KIRKLEES METROPOLITAN COUNCIL INVESTMENT & REGENERATION SERVICE

DELEGATED DECISION TO DETERMINE APPLICATIONS FOR CONSENT, AGREEMENT OR APPROVAL REQUIRED BY CONDITION

Reference No:	2023/44/93082/E
Site Address:	Land Adjacent, 60, Northgate, Cleckheaton, BD19 3NB
Description:	Discharge of conditions 3 (materials), 4 (drainage), 5 (CEMP), 6 (CMP), 7 (temporary drainage), 8 (parking drainage), 9 (noise), 11 (phase I report), 12 (phase II report), 13 (remediation strategy), 16 (integral bat box), 22 (sewer protection), 23 (bird boxes) and 25 (surface water discharge) of previous permission 2022/91730 for demolition of former dairy/snooker centre/storage and erection of 9 light industrial units
Recommending Officer:	Liz Chippendale

DECISION – Discharge of Condition – Split Decision

Figure 4 – Recommended Wall Upgrade

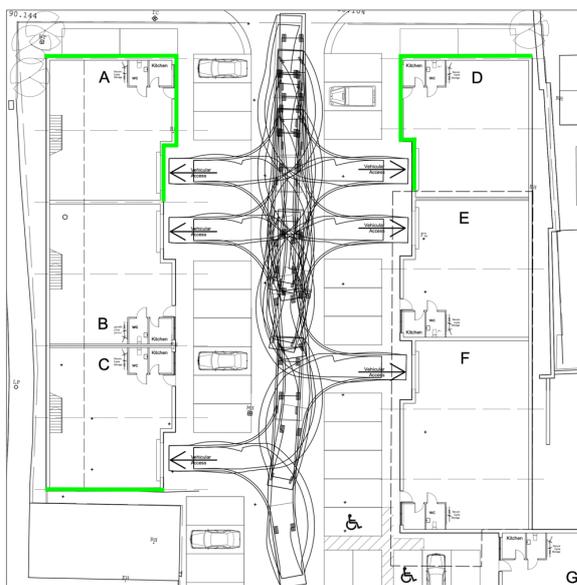
Modelling has been conducted with roller shutter doors open and closed with upper limits on internal noise levels given for each scenario. The modelling is based on typical construction and recommends a wall upgrade to units A, C & D as shown in figure 4. Modelling has also been conducted for the HGV deliveries based upon the levels within BS5228-1:2009 and the findings are shown in the tables in section 6 and in figures 5, 6 and 7.

Officers support the assessment of K. C Environmental Health and consider that the submitted detail are acceptable for the requirements of condition 9, so are recommended to be approved. A note of the conditions ongoing requirement is recommended to be included on the decision notice.

Scott Lane, Cleckheaton, BD19 4JY – S116 Sewer Closure V326571

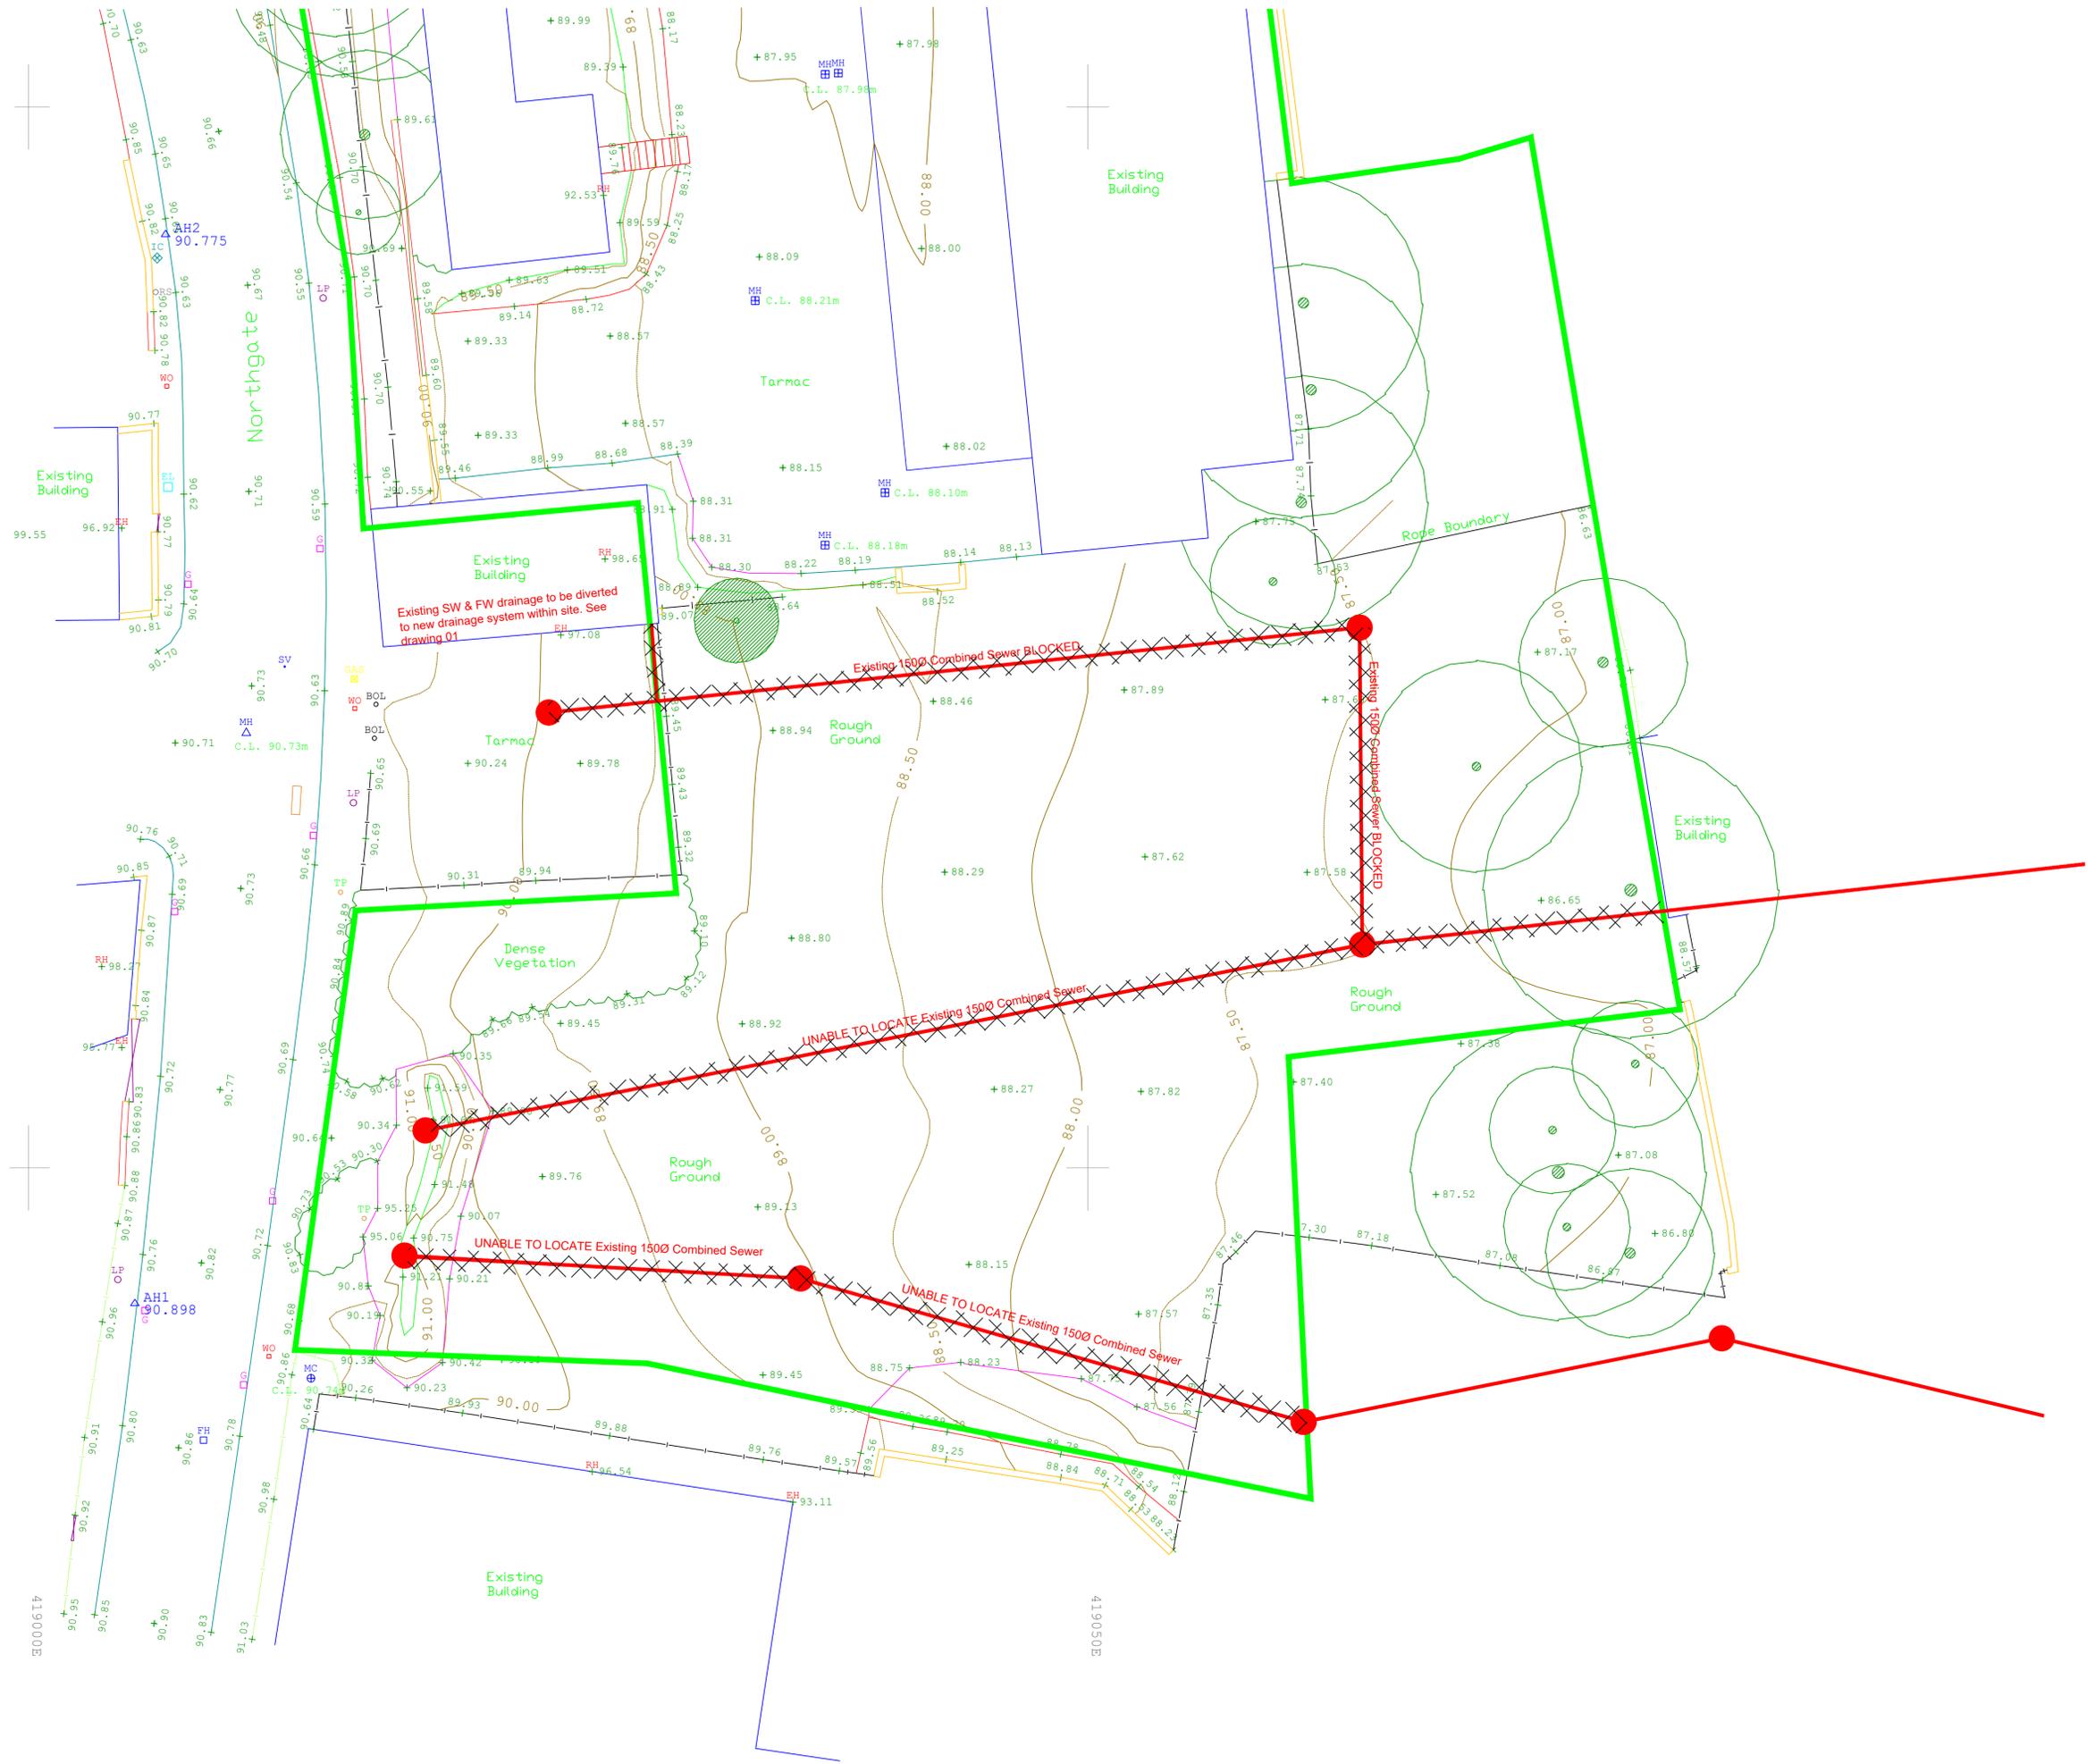
- Object to the closure of sewer as the boundary of the development site (represented in green on drawing EWE/2514/03) has been inaccurately drawn.

No evidence of a formal agreement under Section 185 or Section 116 of the Water Industry Act 1991 that the diversion or closure has been submitted. The developer should also note that the site drainage details submitted have not been approved for the purposes of adoption. If the developer wishes to have the sewers included in a sewer adoption agreement with Yorkshire Water (under Sections 104 of the Water Industry Act 1991), they should contact our Developer Services Team (tel 0345 120 84 82, email: technical.sewerage@yorkshirewater.co.uk) at the earliest opportunity. Sewers intended for adoption should be designed and constructed in accordance with the WRc publication 'Code for Adoption - a design and construction guide for developers' as supplemented by Yorkshire Water's requirements.

*I understand a decision has not been determined about the above application.
Having received further information about the development, I would like to inform you that I withdraw my approval of discharge of condition 22 (no building over sewer) at this stage.*

Response: Yorkshire Water have objected to the discharge of Condition 22 (Sewer closure) due to new information received. Condition 22 will not be discharged at this stage.

It is understood that Yorkshire Water's change in stance came following a public representation being made (detailed above). Given the specific nature of the condition relating to the protection of public water infrastructure, officers deem it reasonable to adhere to the advice offered by Yorkshire Water. Therefore, following the latest objection from Yorkshire Water regarding the S116 sewer closure, condition 22 is unable to be approved and/or discharged at this stage.

Northgate Front Elevation and Gable Walls

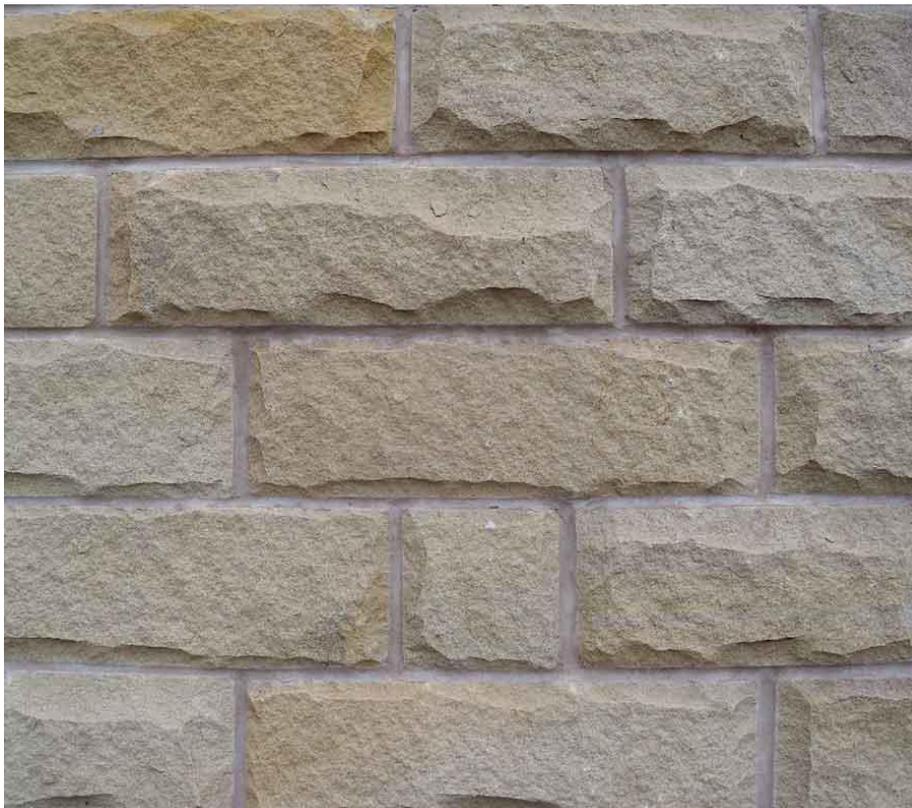
The approved layout has three adjoining units facing directly onto Northgate (units A-C). As originally proposed, the applicant sought for these to be a brick plinth with cladding above. This raised concerns from officers.

As detailed within the latest submission (Rev. A), where the units face onto Northgate road, they would be faced in natural Yorkshire stone with a stone slate roof.

The details provided with the submitted document Condition 3 – Materials and colours Rev A are considered to be acceptable for the purpose of condition 3. The development shall be constructed in the approved materials and retained thereafter.
